Heckington Fen Solar Park

EN010123

Statement of Common Ground with Environment Agency

Document Reference: 7.6d

Drawing file: EN010123 / EN010123-000760-6.2.4 - Figure 4.22 - Substation Control Building - Rev 2.pdf

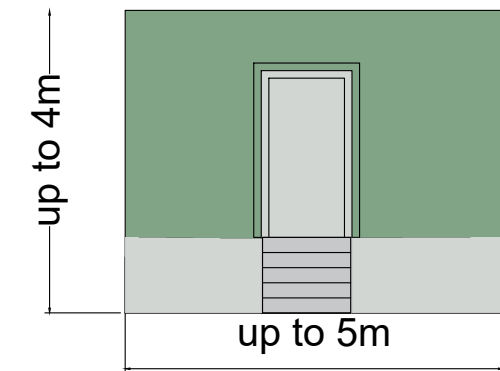
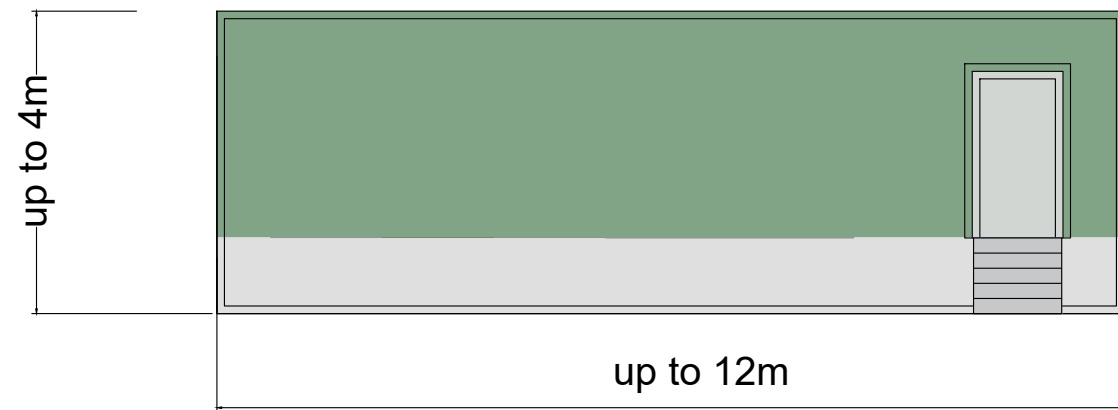
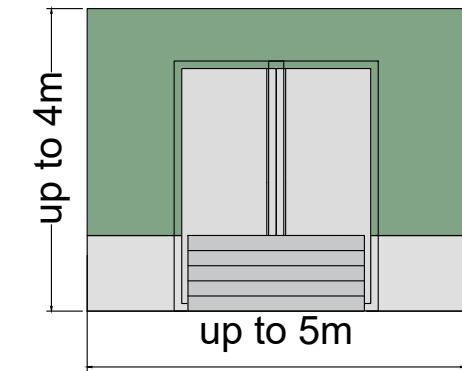
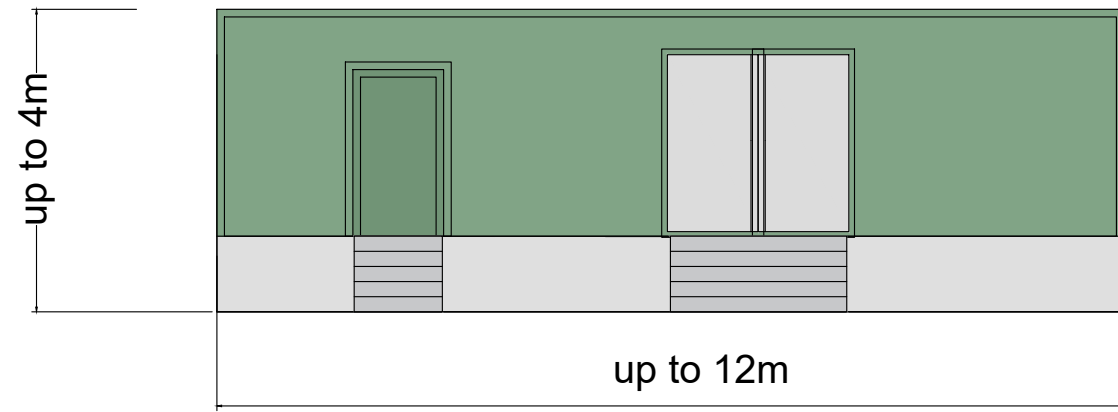
Reference and Status	Topic	EA’s Position	Applicant’s Position
1. Assessment of effects (including survey areas, baseline data and methodology) relating to Flood Risk and Drainage			
1.1. Under Discussion <u>Agreed</u>	Environmental Statement Chapter 9 – Hydrology, Hydrogeology, Flood Risk and Drainage Chapter 9 alongside Appendix 9.1: Flood Risk Assessment, Parts 1 and 2 (Rev 2)	The EA has reviewed the FRA from a fluvial perspective only (other sources of flooding such as groundwater, drainage systems, reservoirs, canals and ordinary watercourses fall under the remit of other flood risk	The Applicant can confirm the finished floor level of the control room at the energy park site will be at or above 2.25mAOD. This could be <u>Figure 4.21 and Figure 4.22 are resubmitted to confirm this.</u>
